MMC traffic information & trip distribution - need for meeting Thursday?

Wed, Apr 25, 2018 at 8:39 AM

VHB Travelshed Analysis

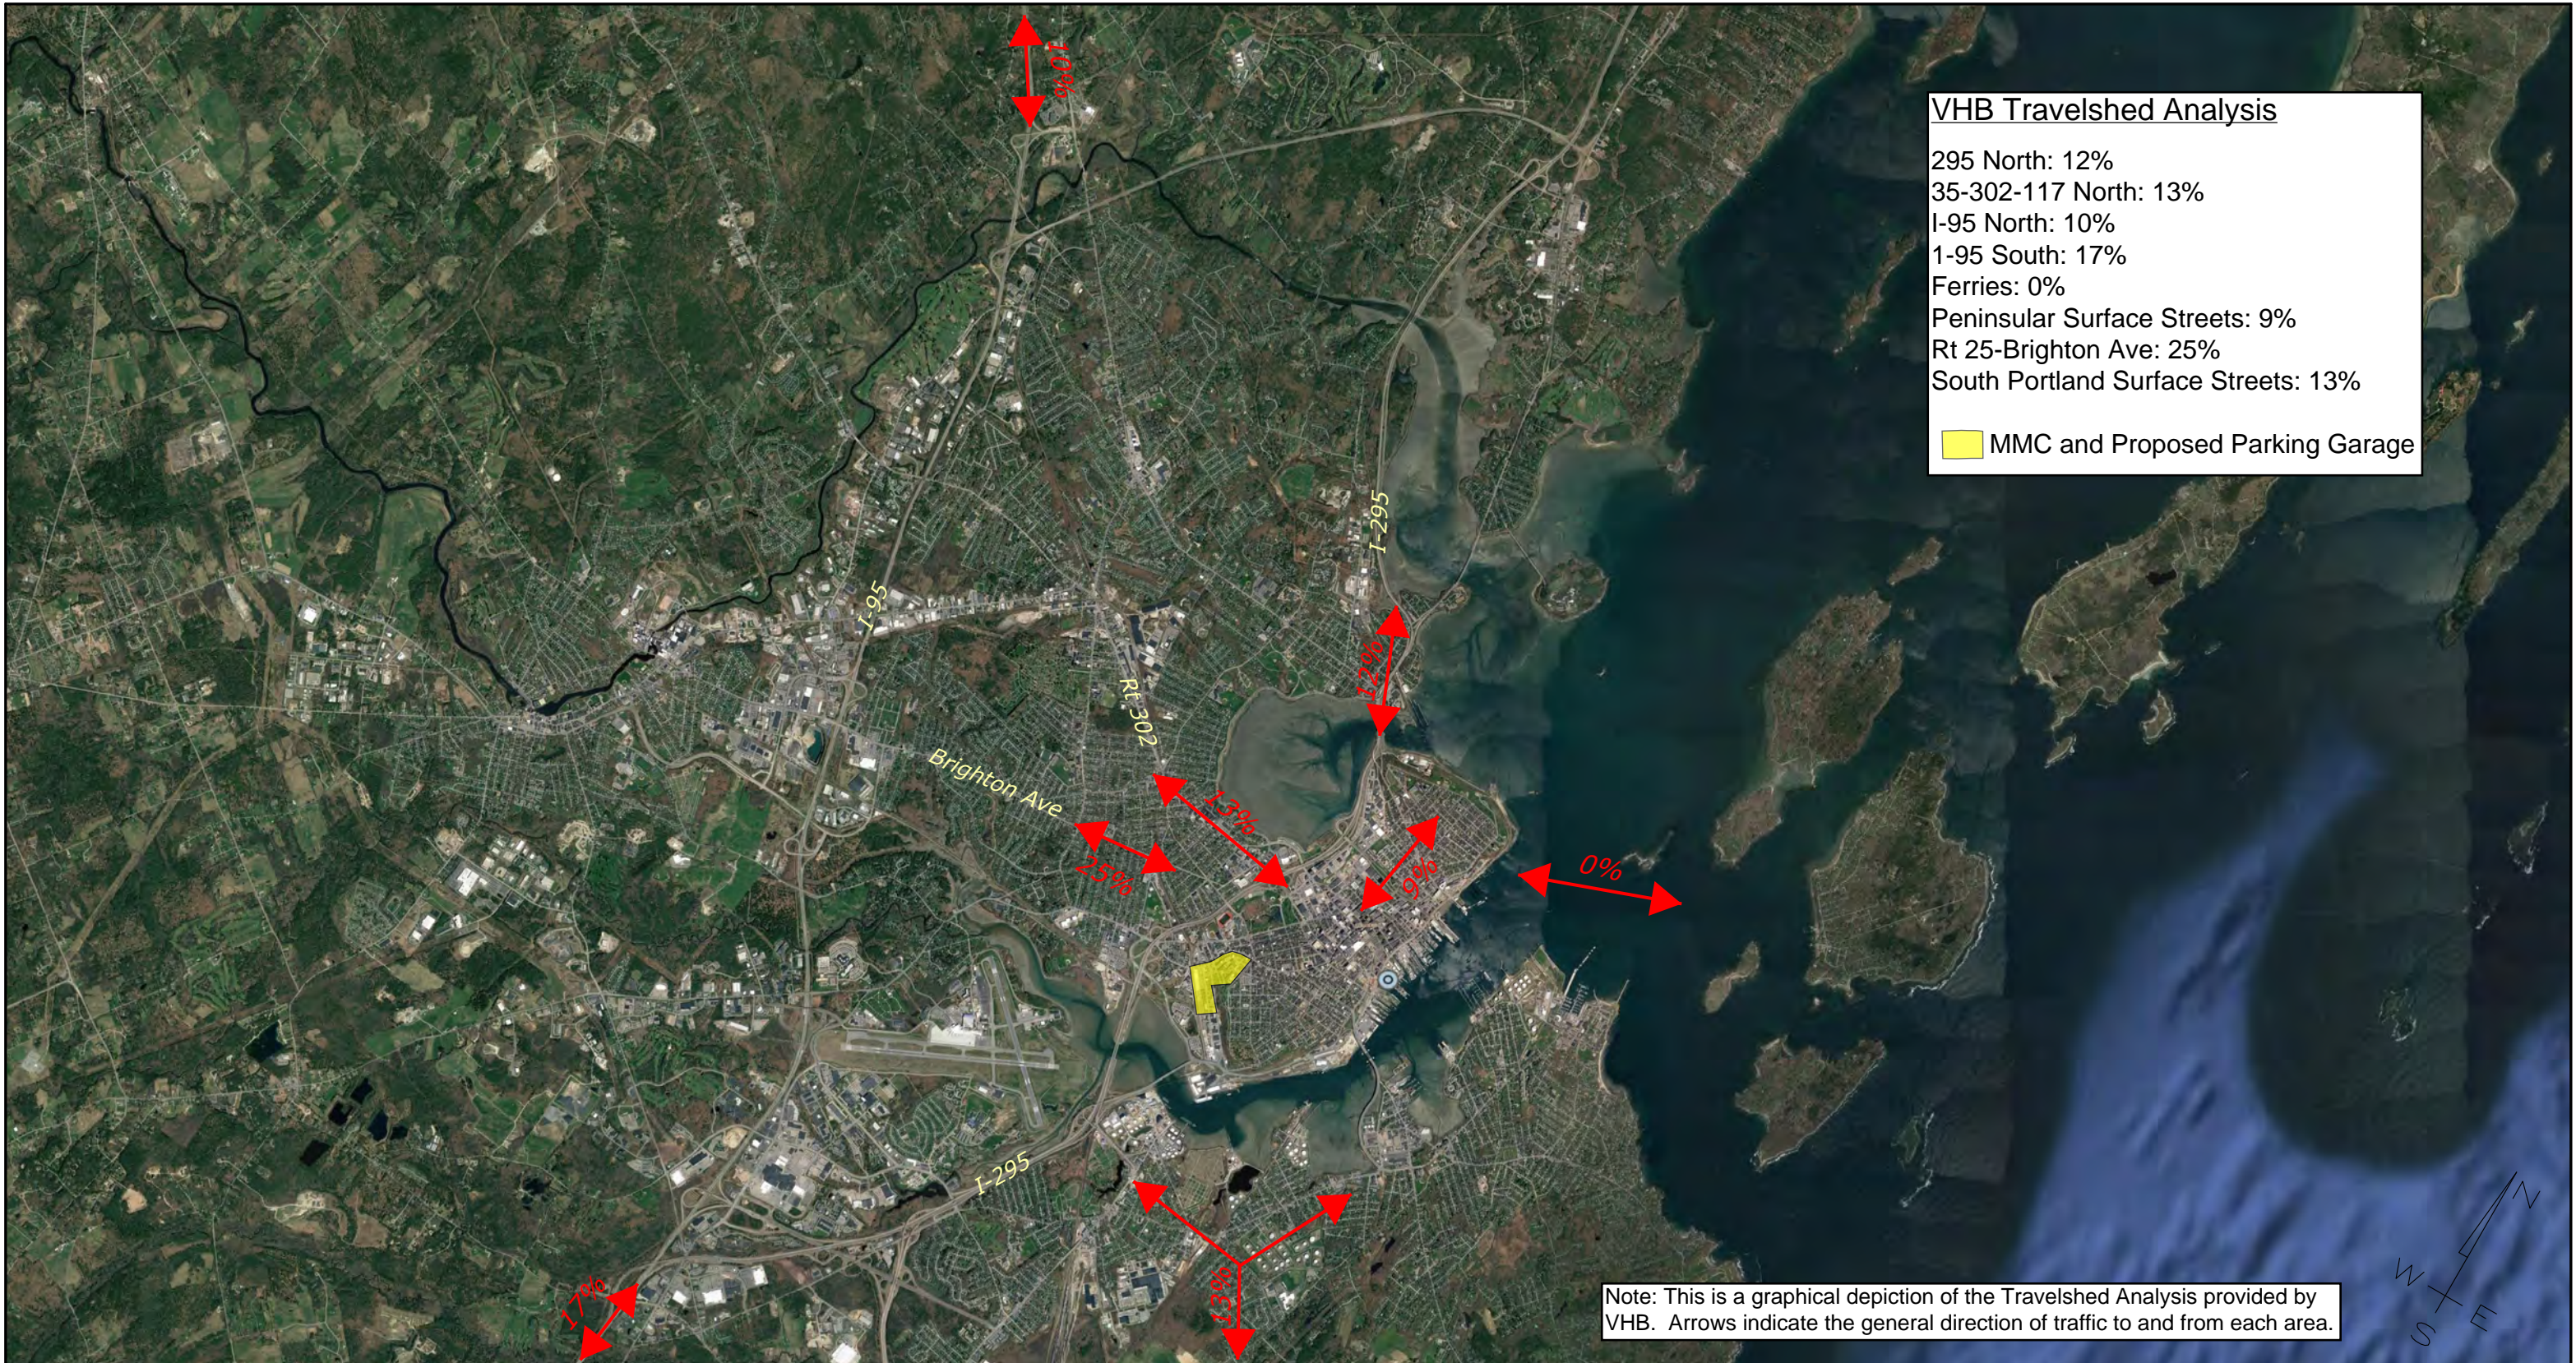
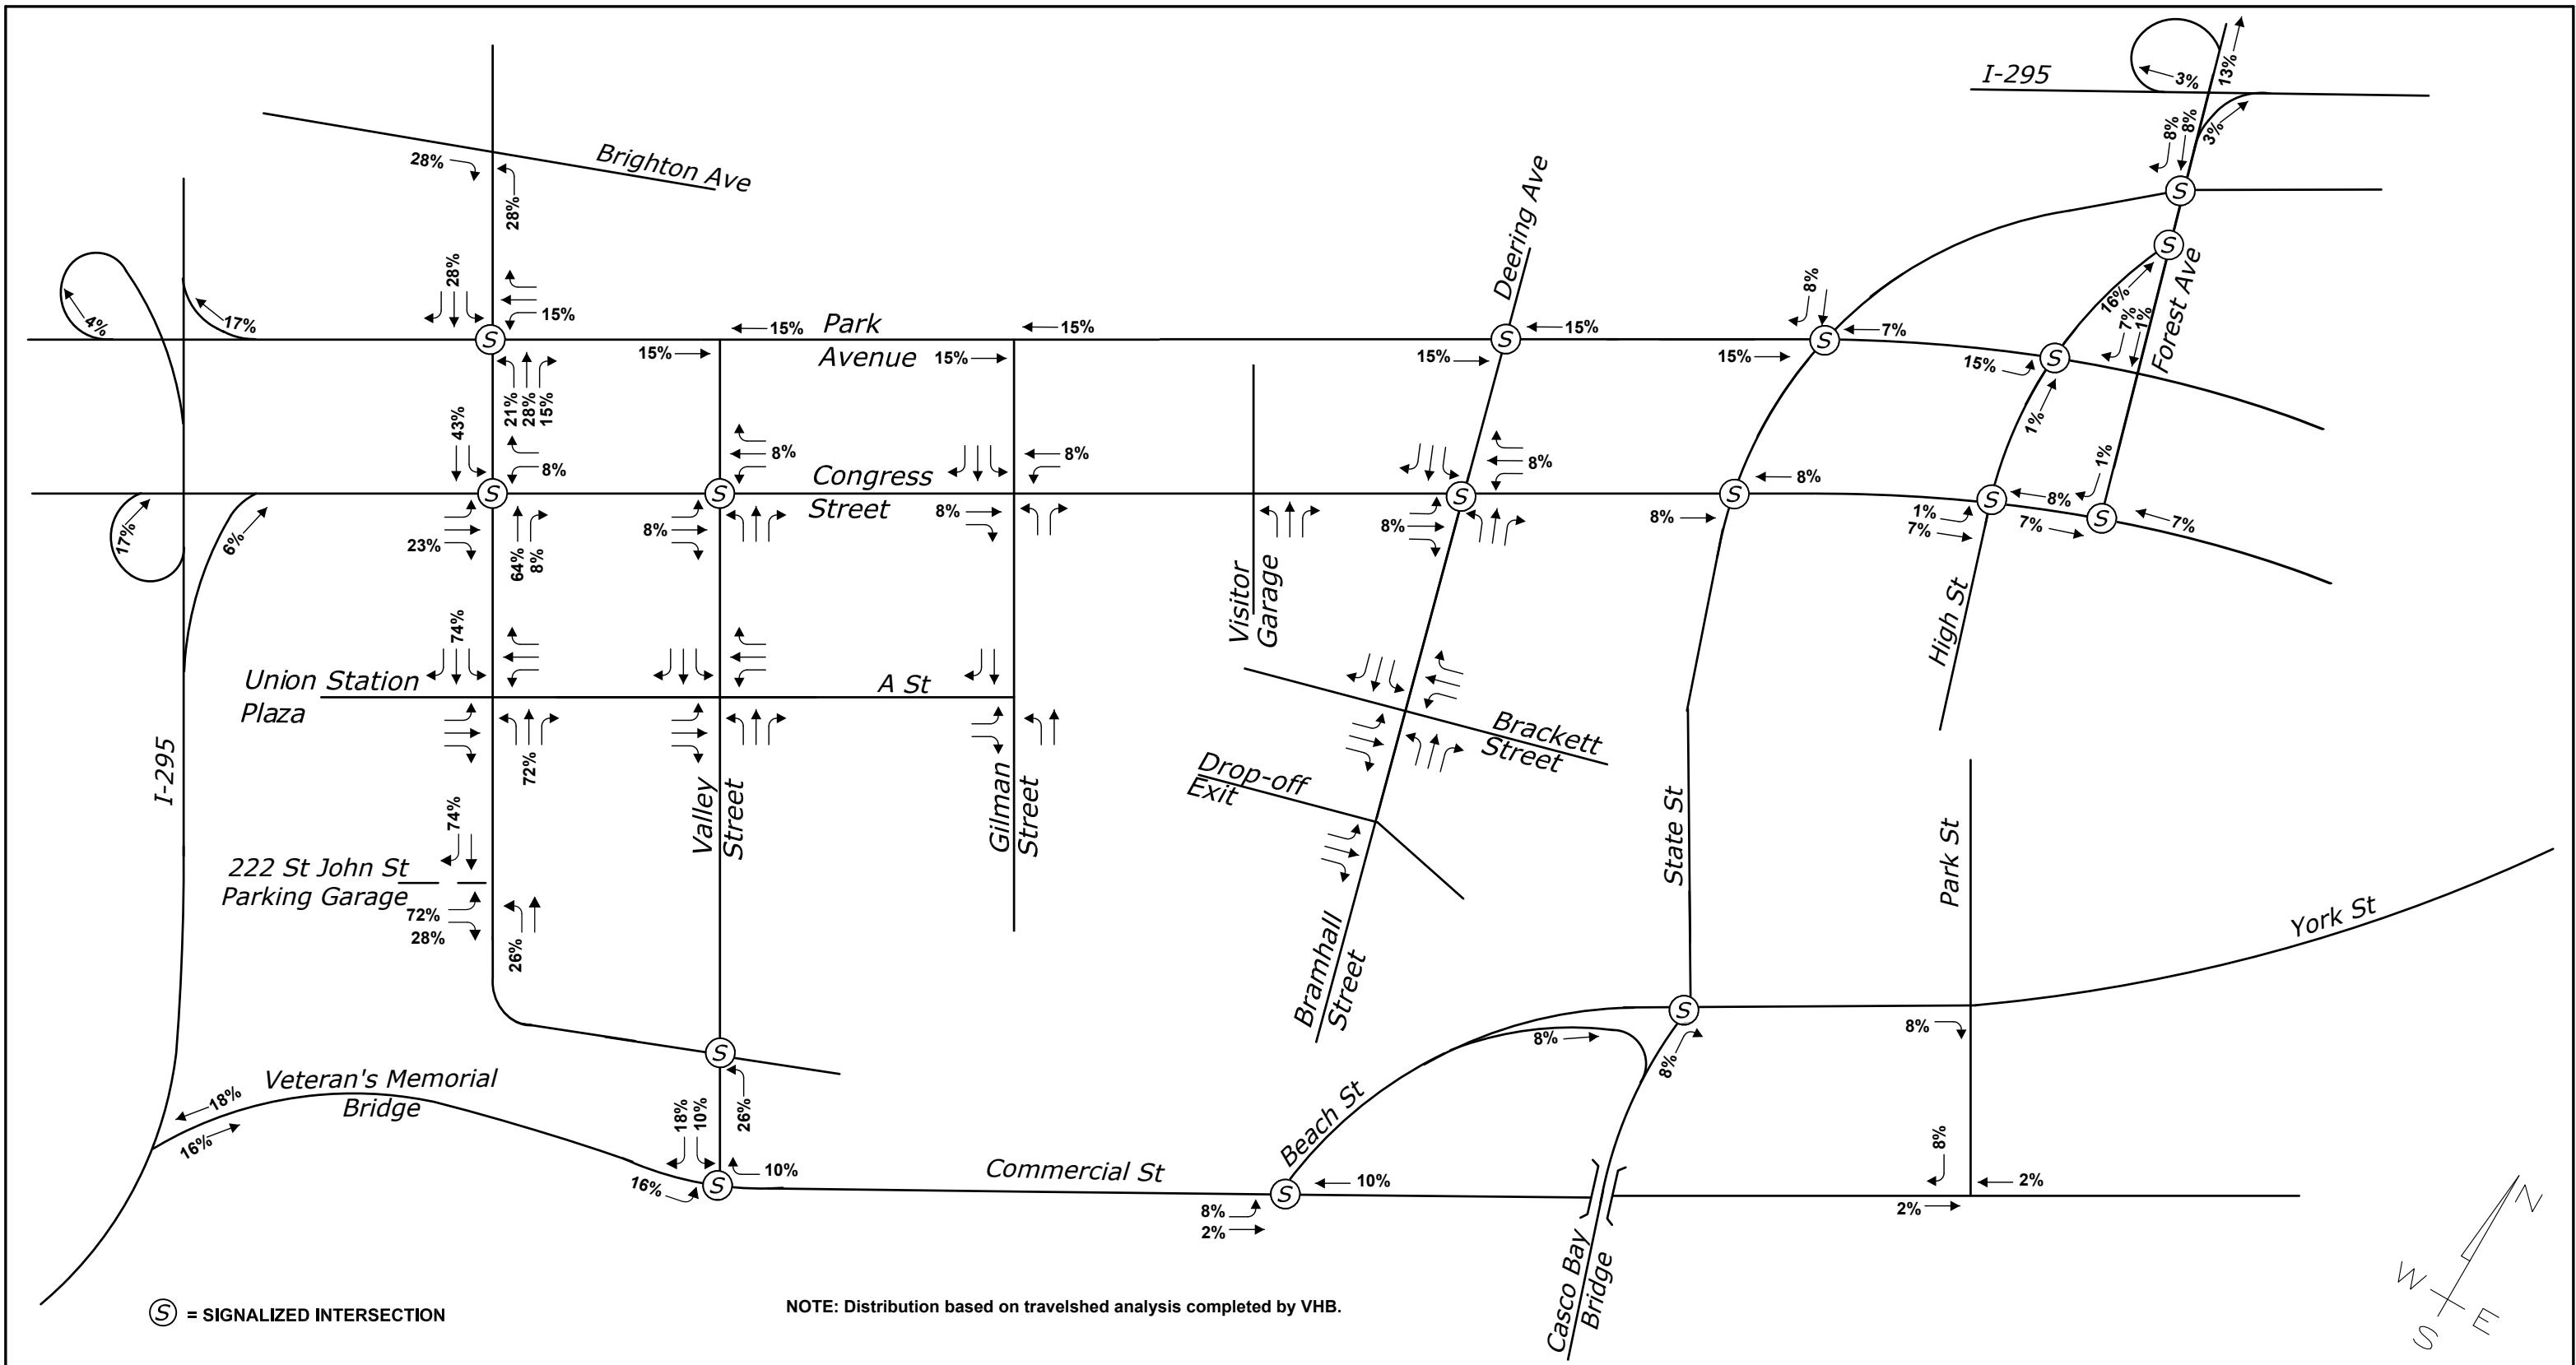
I do have one significant question. The employee residence data is good, and the GENERAL assumptions about travelshed locations seem to make sense. However, were any of those assumptions calibrated with employee travel surveys? It sounds like this is the case, but not sure to the extent of it.

I ask because my specific travel route to work does not synchronize with the assumptions. I live in Auburn, in the I-95 North travel shed, but commute to downtown Portland using the I-295 North travel shed, as do a number of folks particularly on the southeast side of Auburn and downtown Lewiston.

The actual percentages for trip assignment based on the travel sheds would appear to generally make sense to me, although they are likely somewhat conservative for the major in-town routes, as travelers will use any number of methods to accomplish what they feel is an optimal travel pattern.
